ASD 1205
20th January 2021

**Proposed rear extension to form a take Away kitchen and store at bar Aldo's 9 – 11
Coalgate Alloa FK10 1EH**

With reference to the above and the earlier application 20/00123/FULL submitted 18th June 2020, which was withdrawn on the 7th September 2020.

RD35S-4D

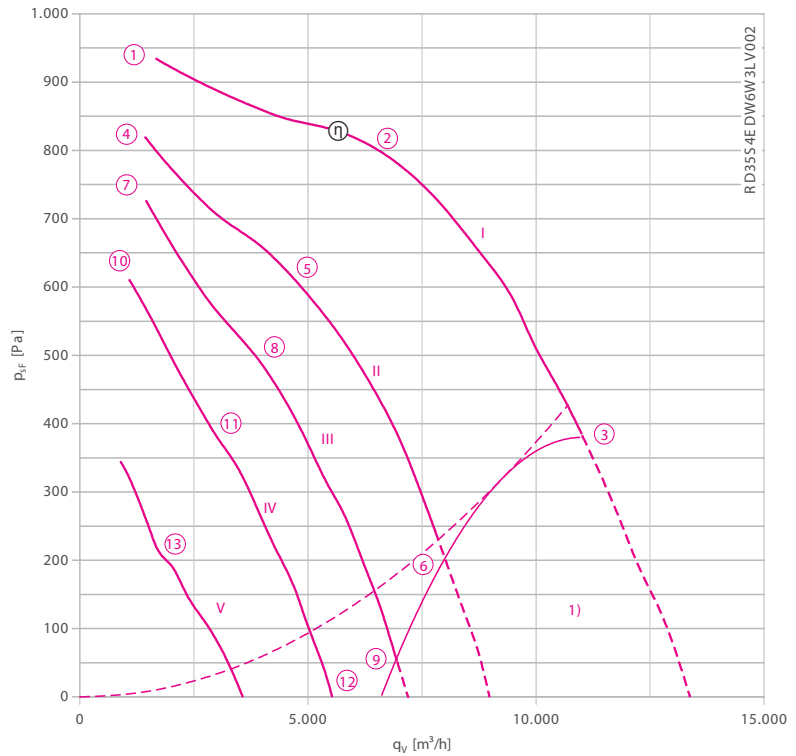
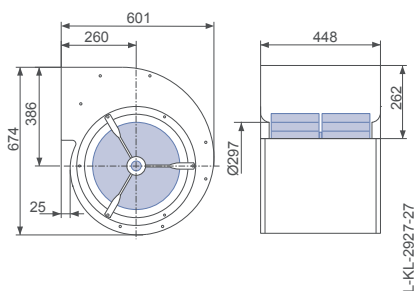
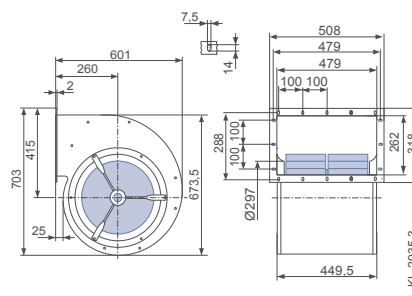
4. The existing kitchen extract flue has been checked out to establish if it was suitable to cope with the additional extract canopy. It has now been confirmed but it has been suggested that the existing fan be replaced with a new, more modern type. The contractor that carries out the maintenance of the existing system confirmed that the new fan would be quieter than the existing, but their intention is to form an acoustic box around it to reduce the noise levels further. As the box is built insitu there are no information on what the noise reduction would be. At present the fan is located in a timber shed / store, outside the main building and to date there has not been any issue with noise from the neighbours above the restaurant.

PROPOSED NORTH ELEVATION  
SCALE: 1:100

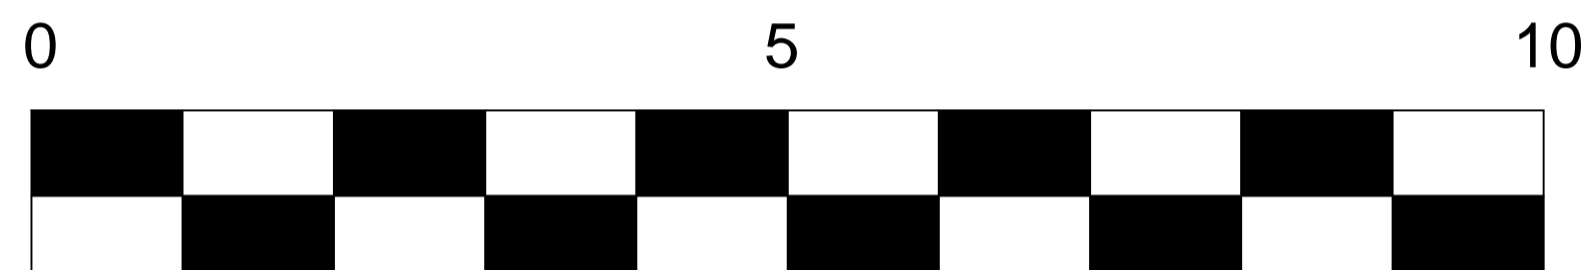
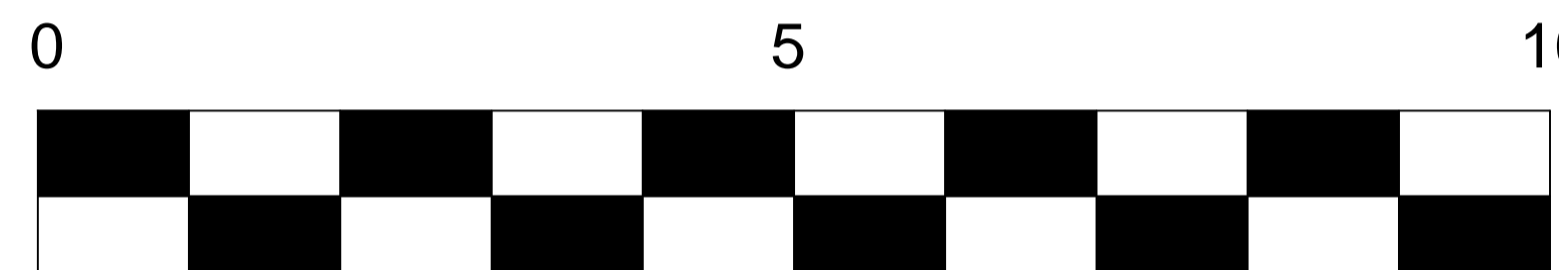
1. The footprint of the building has been reduced to address the comments from an adjoining neighbour.
2. The roof configuration is amended to match the earlier approved and lapsed application.

3. The collection window has been removed and replaced to match the earlier approved application and raised margins have been added around the door. The door will be used as the kitchen staff entrance and also the collection point for the deliveries and collection of the take away meals.
